**University of Technology Sydney
Blackfriars Precinct Research Building Industry Hub
4-12 Buckland Street Chippendale NSW**

Response to Submissions

Section 4.55(2) Modification Application

**SSD 6746 Blackfriars Concept Development Proposal
UTS Blackfriars Precinct Research Building**

DETAILED SHADOW ANALYSIS

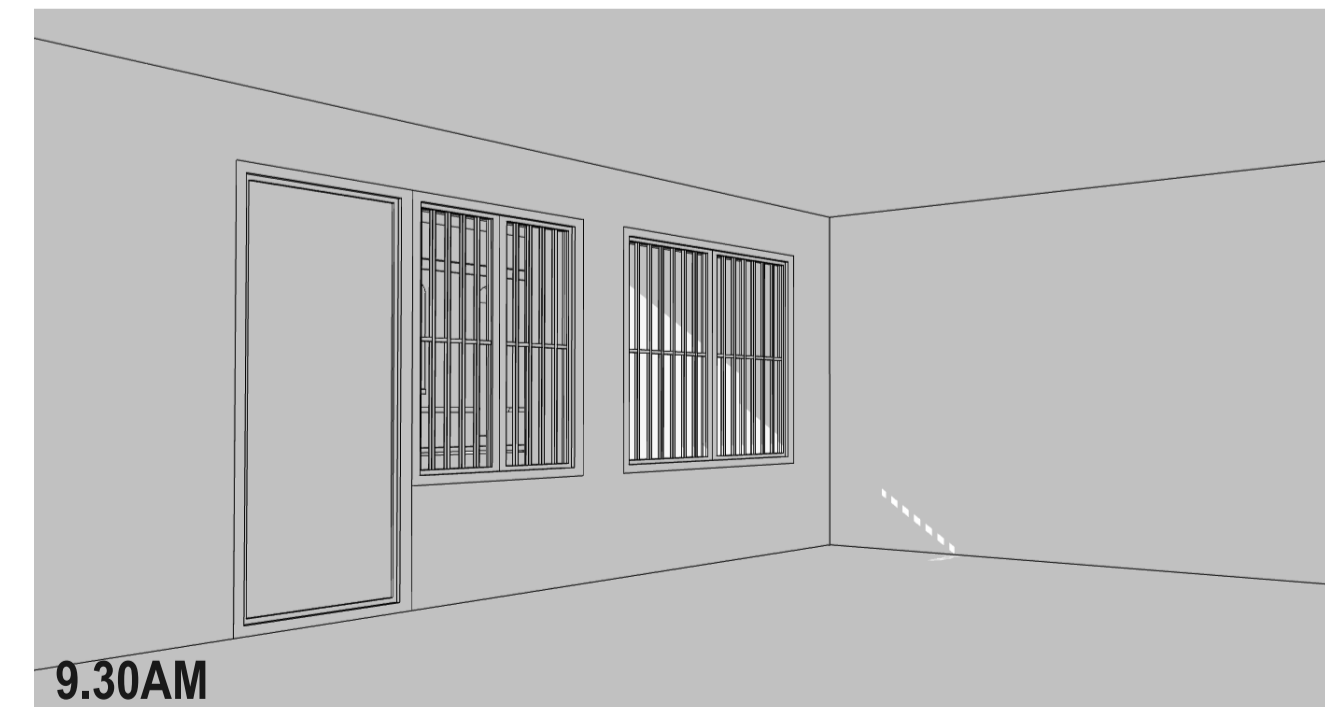
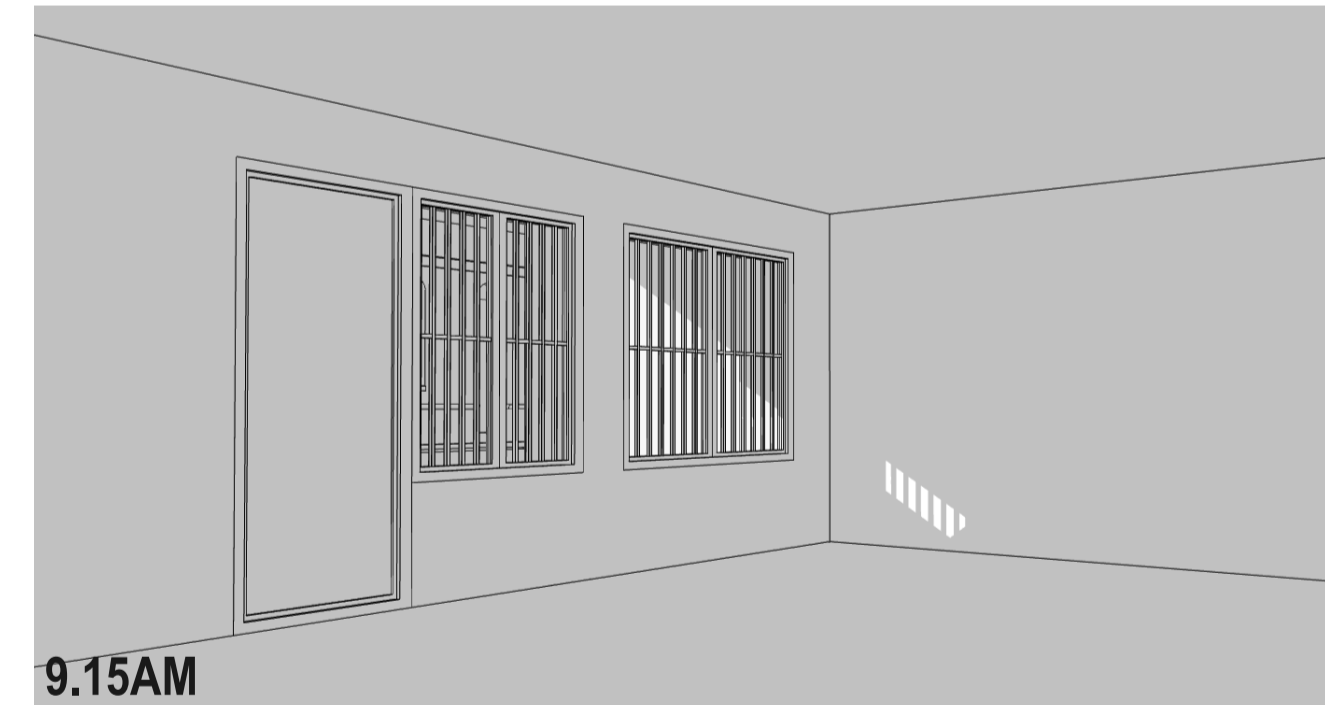
Council has raised a concern that the overshadowing information provided with the modification application is inadequate and it has questioned whether two hours solar access to 2 Grafton Street apartments is maintained. Council has also noted its position that solar access cannot be relied on to these apartments after 11.30 due to the orientation of Grafton Street – refer to Council's comments 1.d) at page 2 of its submission.

TZG architects have modelled both the existing solar access within the living room of this apartment and the solar access resulting from the proposed development (see Figure 4). This extraordinary level of detail shows that the living room of Unit 29 currently achieves some direct midwinter solar access after 9am but:

- does not achieve 2 hours of midwinter solar access after 9am (it instead achieves approximately 45minutes of direct sunlight after 9am)
- does not achieve effective solar access (defined in the ADG as being a minimum of 1m² of direct sunlight, measured at 1m above floor level, achieved for at least 15 minutes)

After the proposed modification, Figure 4 shows that:

- the living room of Unit 29 will still achieve approximately the same duration of midwinter solar access after 9am that it currently achieves but with the amount of sunlight partially reduced in area
- the shadow from the proposed development will not cause the unit to fail to meet the State policy regarding midwinter direct solar access

PROPOSED ENVELOPE PLAN 1:250 @A1

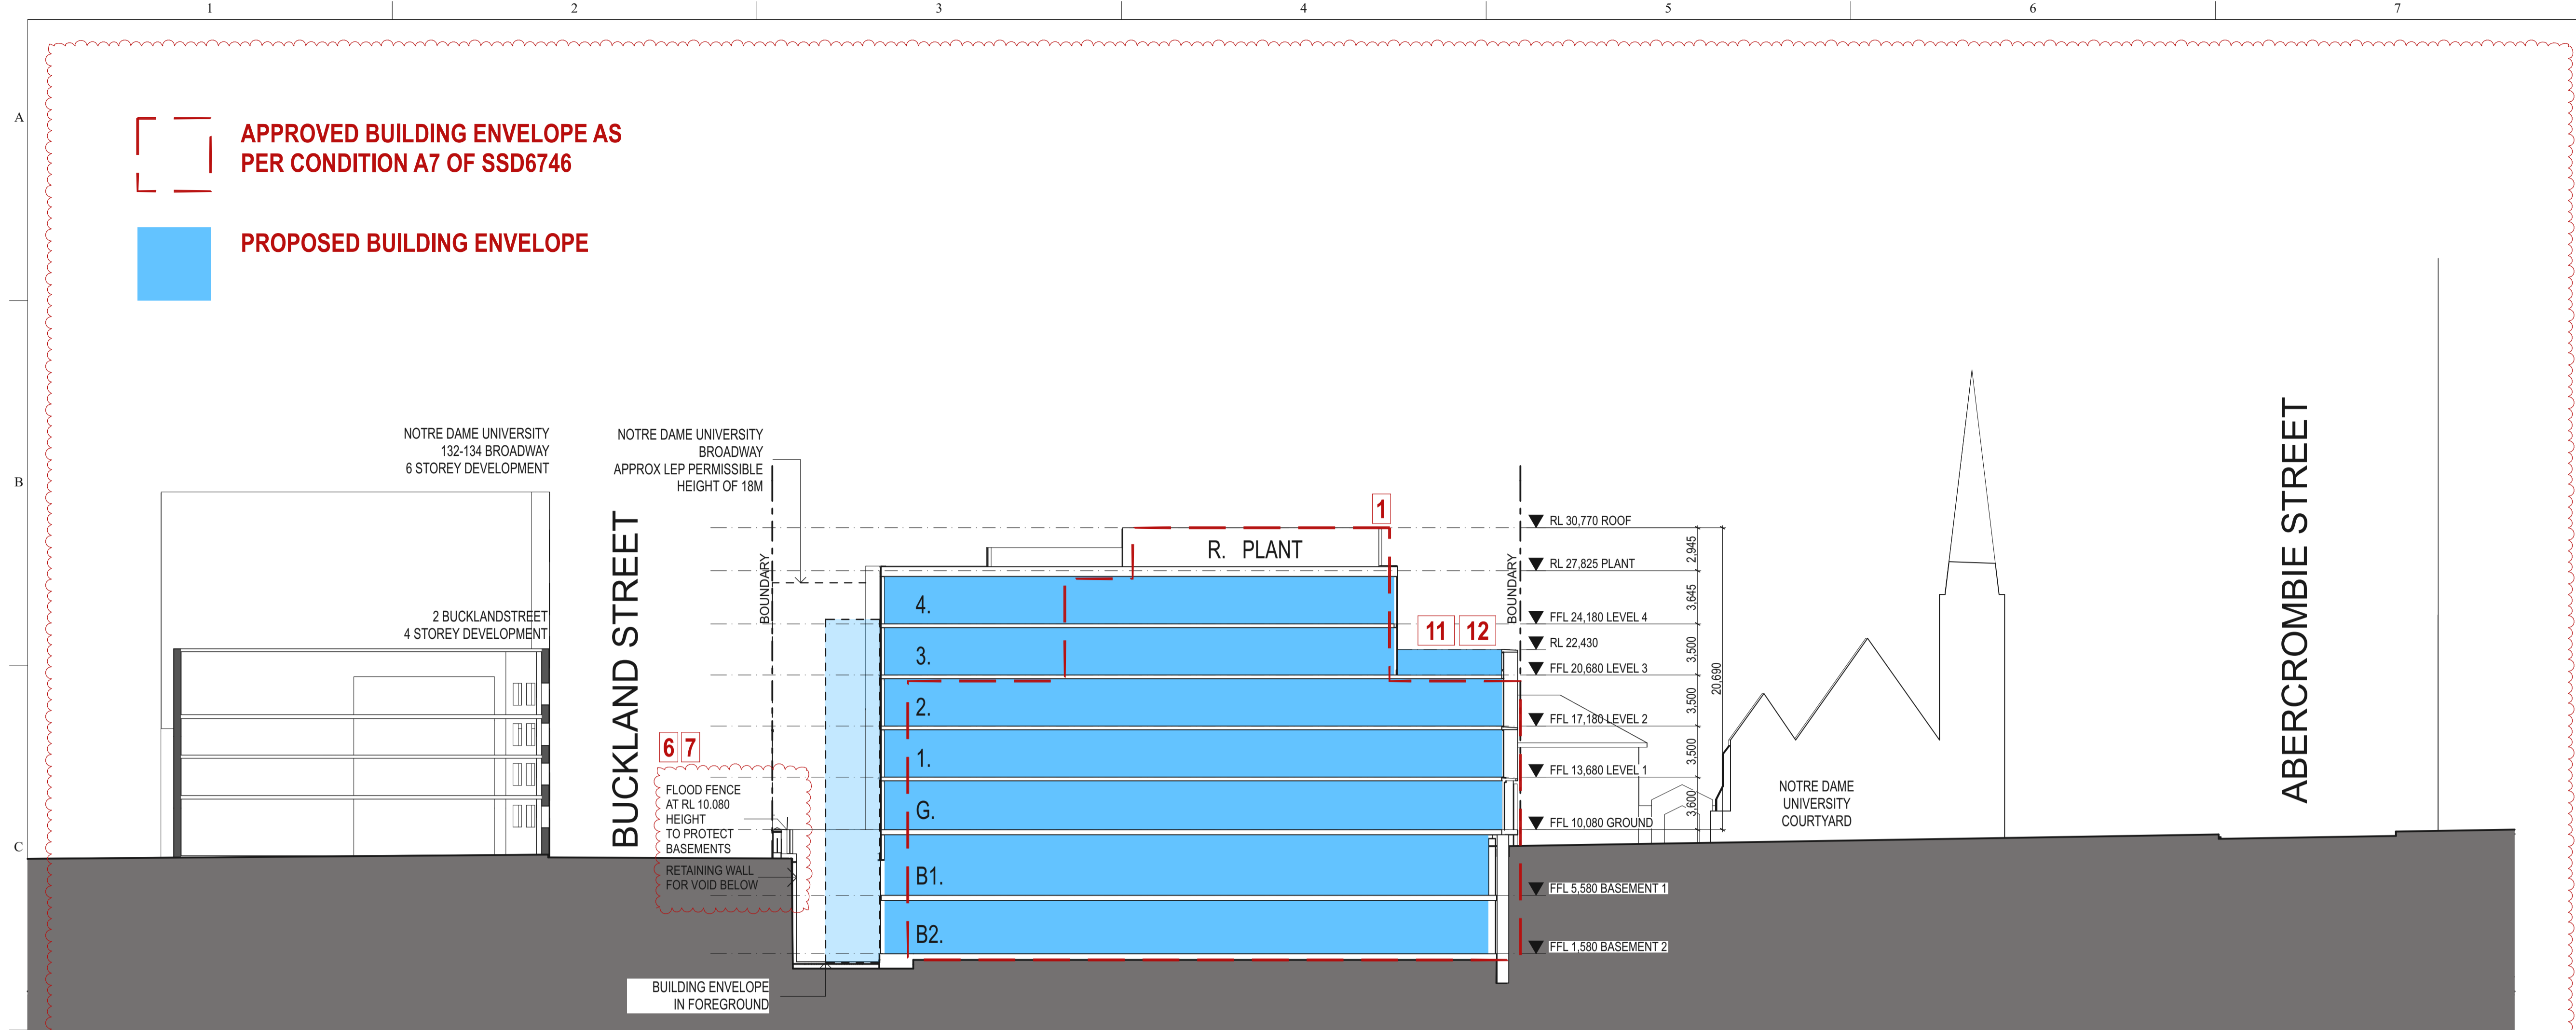
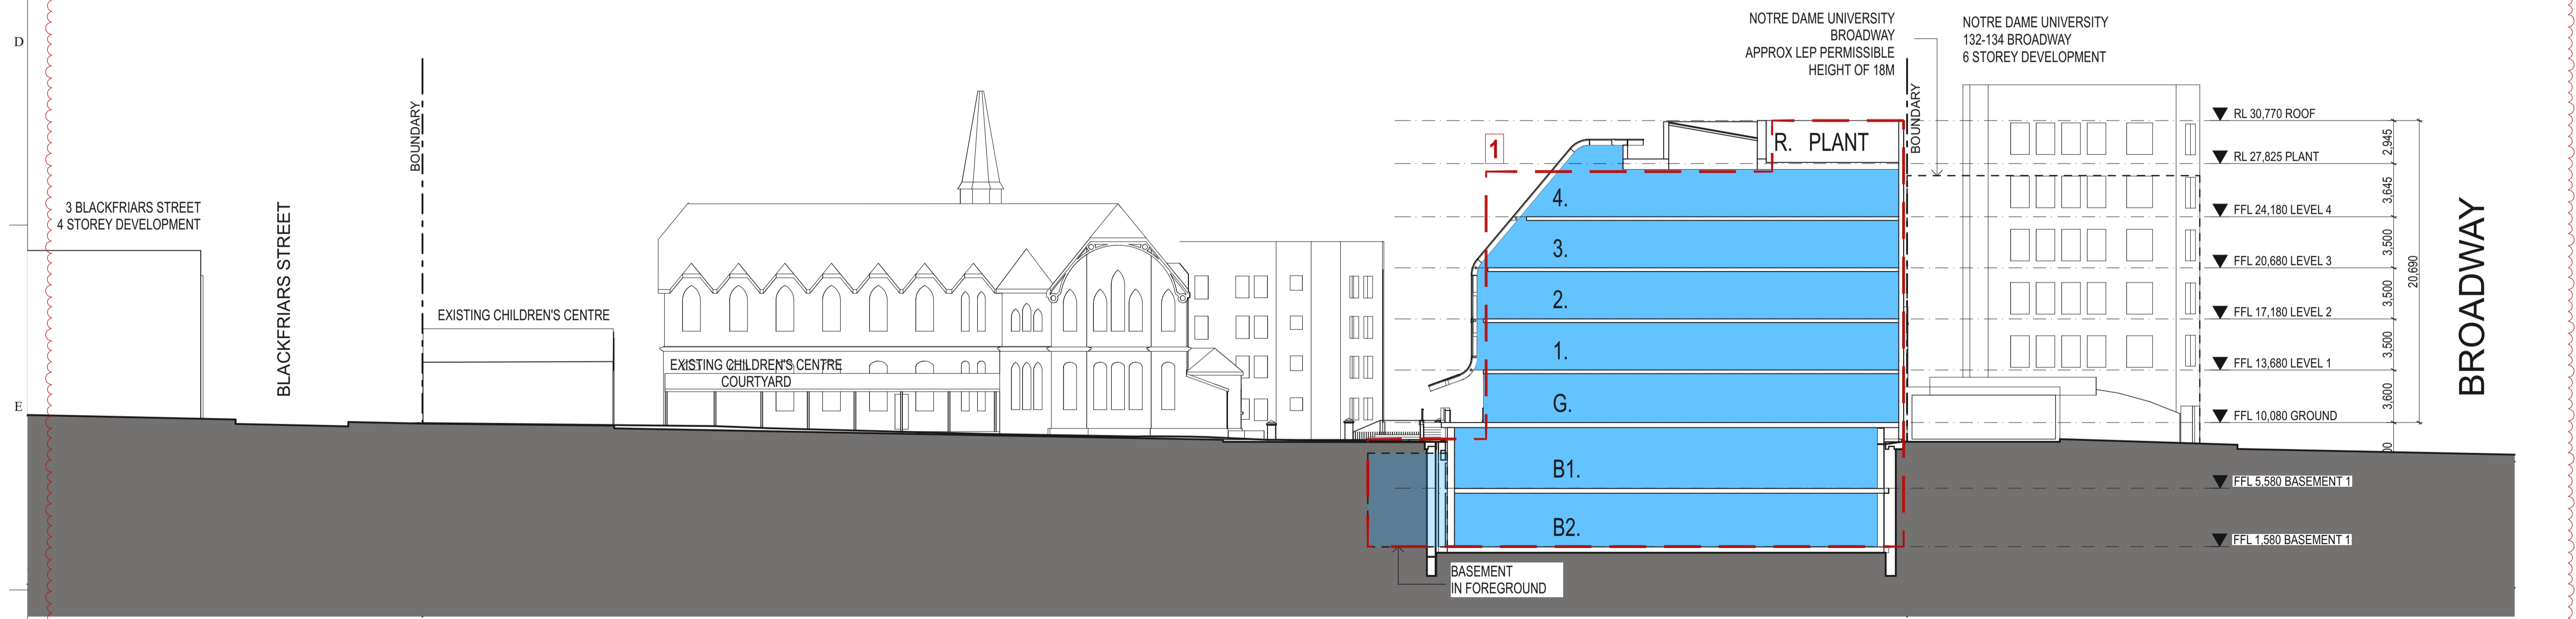
Council has raised a concern that the proposal seeks to completely remove and replace the heritage significant fence – refer to Council's comments 1.a) at page 1 of its submission.

- For clarity, the notes on drawing A02 - PROPOSED BUILDING ENVELOPE PLAN have been changed from "EXISTING HERITAGE FENCE TO BE REMOVED AND REUSED" to "EXISTING HERITAGE FENCE TO BE SALVAGED AND TEMPORARILY REMOVED THEN REUSED/RESTORED". An amended Drawing A02 with this change is attached and the proponent is happy to substitute this plan to satisfy Council's concern.
